From: [Scott Anderson](#)
To: [Wolfenbarger, Jeanne](#)
Subject: Re: AA Comments
Date: Monday, August 31, 2020 9:06:52 PM
Attachments: [image001.jpg](#)
[AERIAL PHOTO FOR REFERENCE.JPG](#)
[AA HANOVER BUSINESS PARK 1.pdf](#)
[6500 Hanover NW TCL.pdf](#)

Include a copy of existing site layout for parking that was approved to **decifer** the changes for the parking lot.

Provide vicinity map of where modified **building** and parking spaces are within approved site. I **believe north** arrow on "TCL" may be oriented incorrectly, but I am unsure.

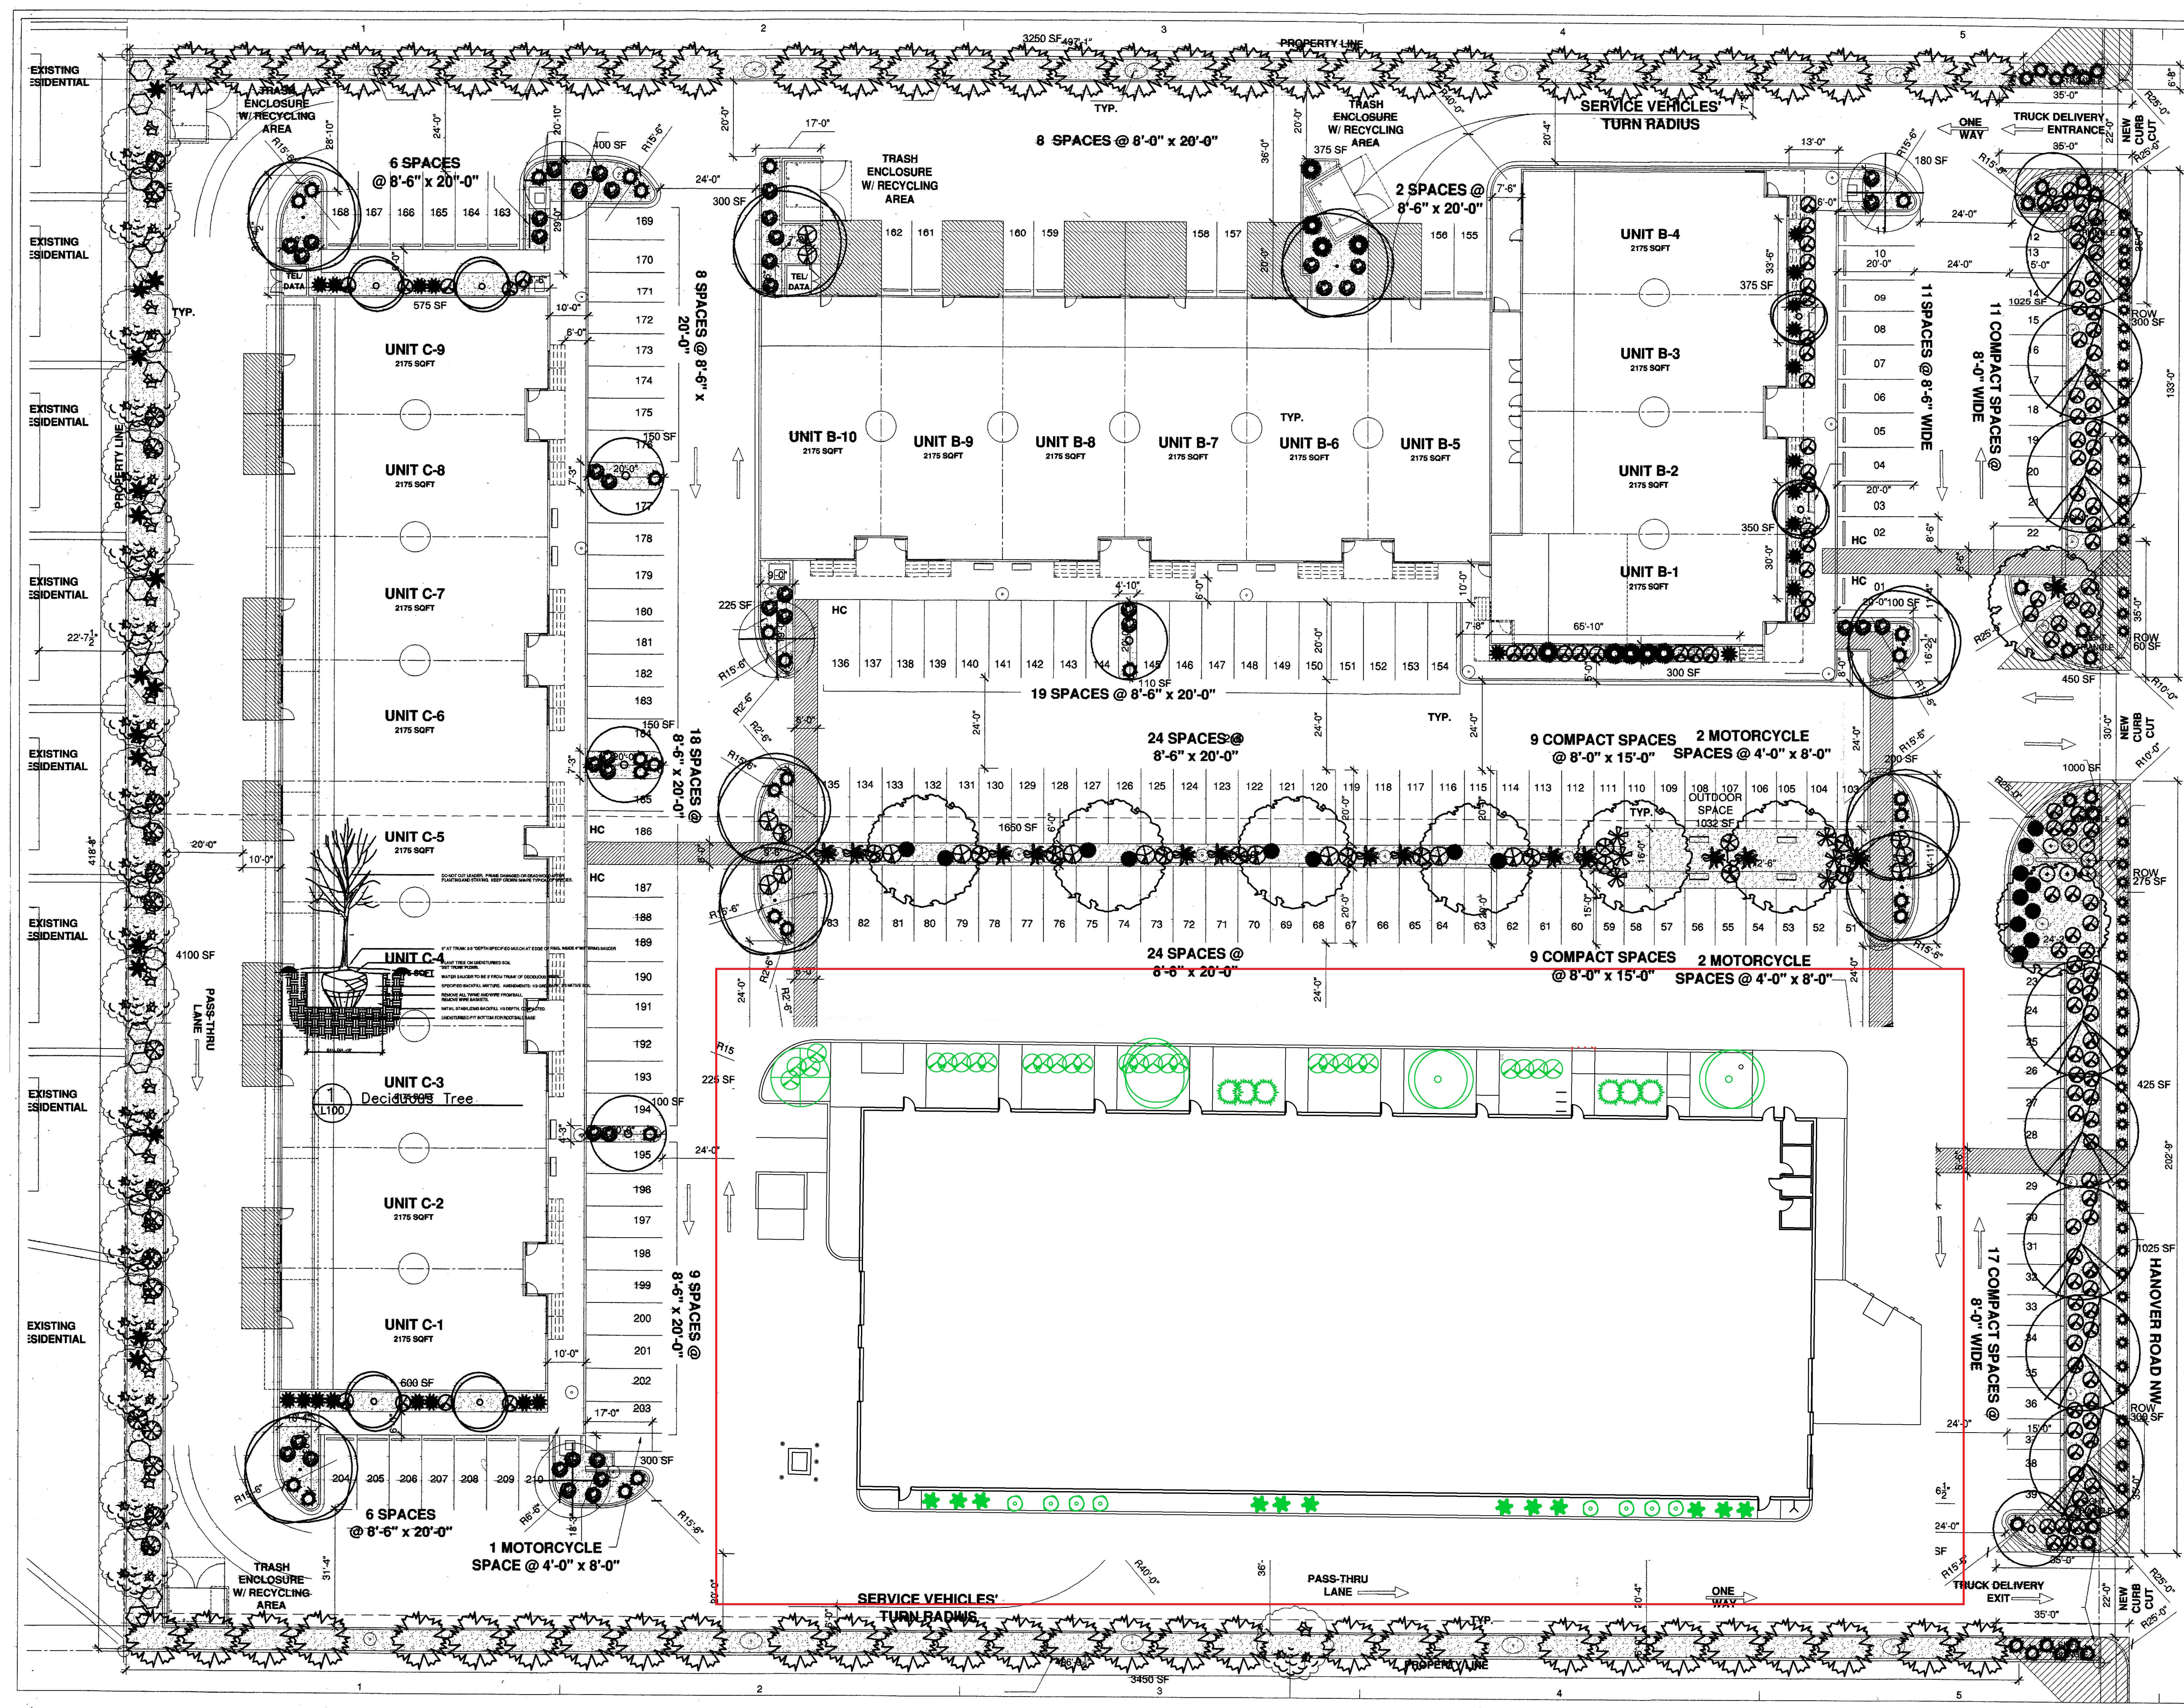
Show parking calculations and all ADA parking calculations.

Show parking stall dimensioning and all aisle dimensioning for the changes to the site. Minimum standards shall be followed.

For any compact parking spaces, there is a maximum threshold in the IDO. Make sure all compact parking spaces are marked as "Compact".

Is there an accessible 6-foot route to the right-of-way? That needs to be identified within the submittal.

Provide new curb detail on the sheet and any handicapped ramp details as needed. Indicate any new curb radii.

Call **out paved** surface on the **plan**.

Label any walkways and their width. I am unsure of the linework surrounding the building.
Dimensions added and noted with keyed note "Q"

The ADA access aisle shall have the words **"NO PARKING"** in capital letters, each of which shall be at least one foot high and at least two inches wide, placed at the rear of the parking space so as to be close to where an adjacent vehicle's rear tire would be placed. (66-1-4.1.B NMSA 1978) . This needs to be enlarged on site detail.

The ADA accessible parking sign must have the required language per 66-7-352.4C NMSA 1978

"Violators Are Subject to a Fine and/or Towing." This needs to be enlarged on site detail.

See attached

Added to upper right corner

Indicated just above the title block

Noted

Compact labels added

Accessible route noted see keyed note "AE"

Detail added to sheet and radii dimensions added to plan

New paving indicated with solid gray hatch see keyed note "AC". Existing paving indicated with keyed note "AD"

"NO PARKING" added to the plan

Reference sign detail on the sheet.
